From: Anita Gardner <Anita.Gardner@arun.gov.uk>
Sent: 21 April 2021 10:34
To: Planning.Responses <Planning.Responses@arun.gov.uk>
Subject: FW: Development adjacent to Toddington Lane Farm Cottages

Re: Development adjacent to Toddington Lane Farm Cottages

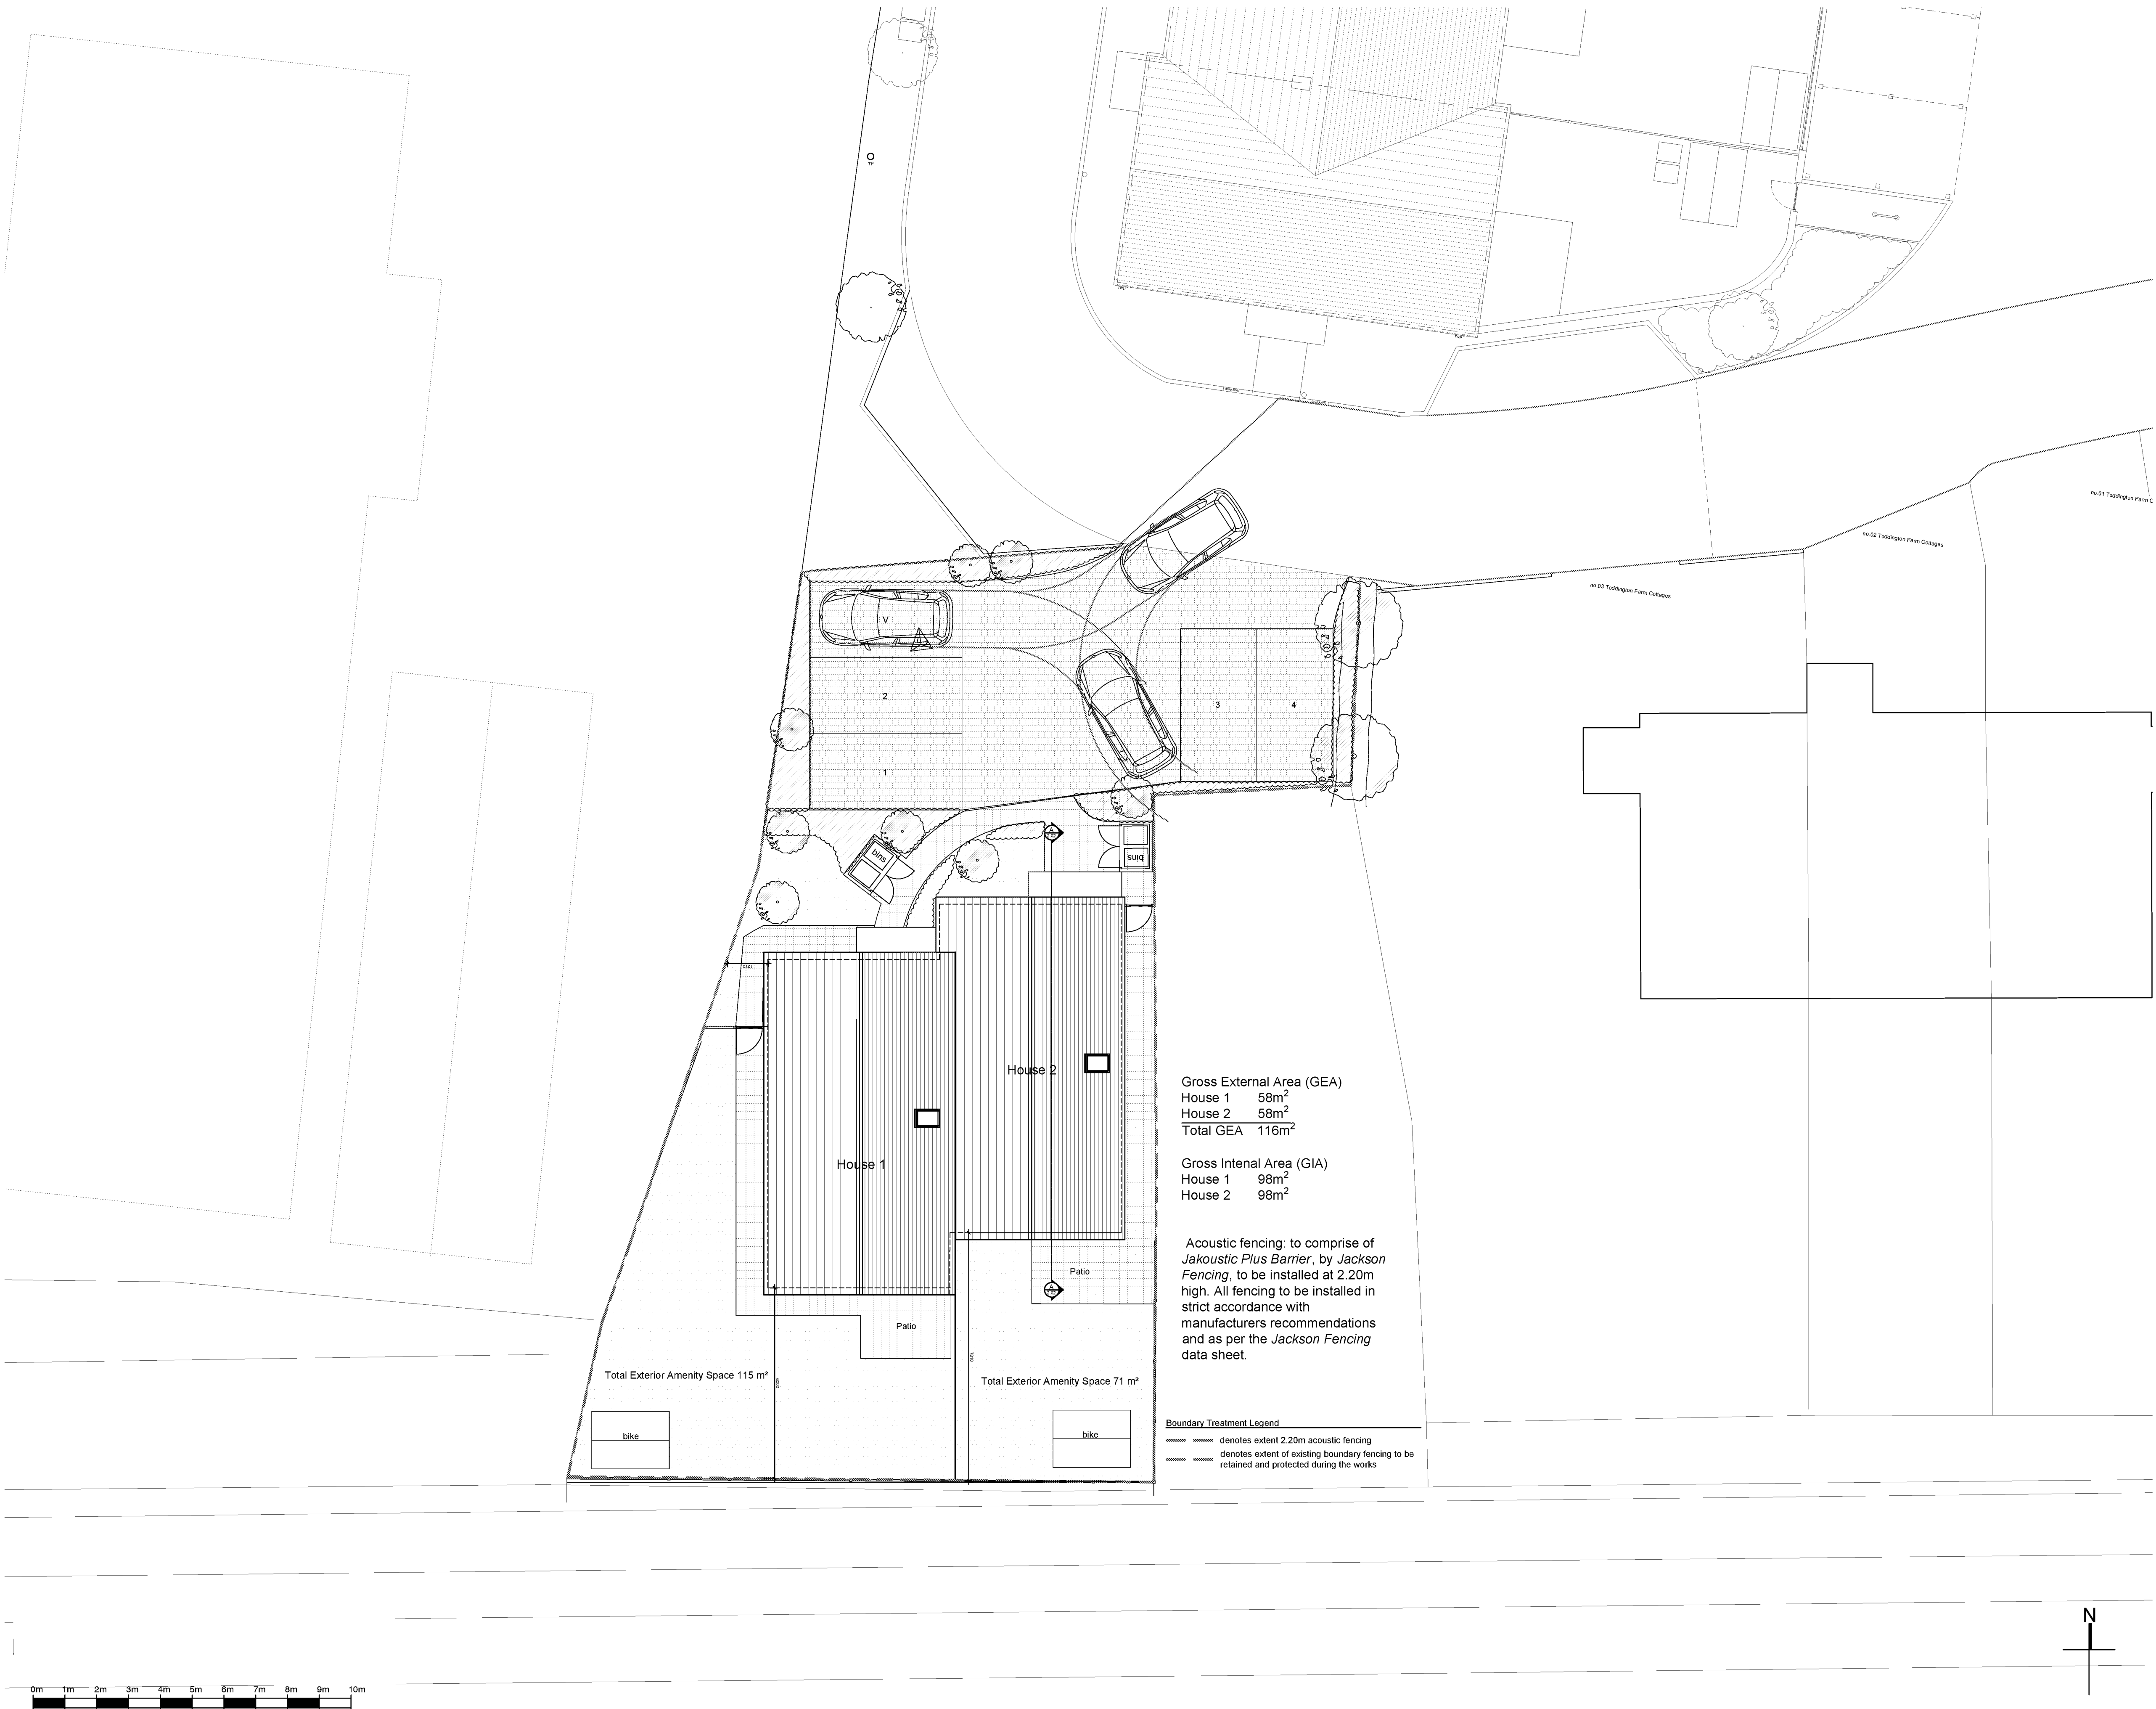
Peter,
It isn't only the size, it also the depth. They fall way short of the 10.5m referred to in the Design Guide in respect of residential amenity.
I can add the e-mail you have sent, to the application, to clarify the garden sizes on the adjacent development, but I'm not sure that is necessary to provide a plan. I leave it to you. If you think it helps your case then could you let me have it by the end of today?
Regards
Anita

We have double checked the rear garden amenity spaces for the previously submitted scheme to the site north of our application site and can confirm the following: (noting that Folkes Architects undertook the Detailed Design and Discharge of Conditions for the site)

P1 – 65 m²

P2 - 56 m²
P3 - 74 m²
P4 – 49.6 m²
P5 – no amenity as first floor flat
P6 - 78 m²
P7 – 86.6 m²
P8 - 82 m²
P9 – 77.6 m²
P10 - 91 m²

These private amenity areas are comparable to those proposed within the current application, which are stated as 71 m² and 115 m² respectively.
